Laurie Leader - Re: BP#2015-02876 3 Stratton Place - Plan review comments

From: Matt Peters <matthewjamespeters@gmail.com>
To: Laurie Leader <LRL@portlandmaine.gov>
Date: 1/27/2016 9:02 PM
Subject: Re: BP#2015-02876 3 Stratton Place - Plan review comments
CC: Chelsea Peters <chelsea.e.peters@gmail.com>

DETAIL of NEW WALLS

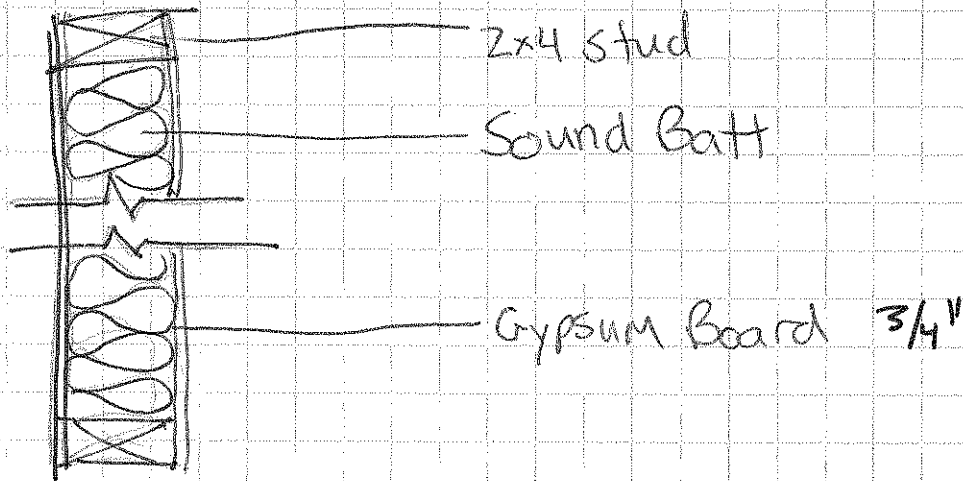
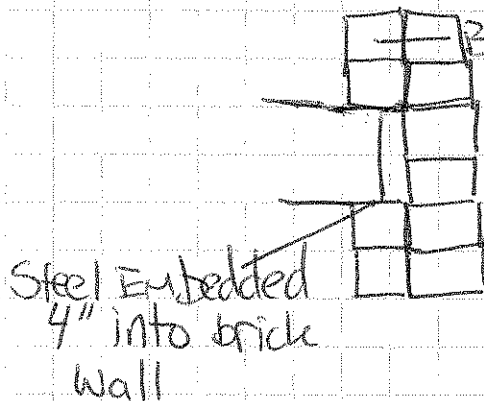
I have also added a condition for approval regarding the steel beam installation in the kitchen. We will need further documentation submitted to our office once the ceiling has been removed prior to starting the structural work from your structural engineer.

Regarding the kitchen comment, it was our intent to complete demolition and bring the structural engineer in again for final engineering.
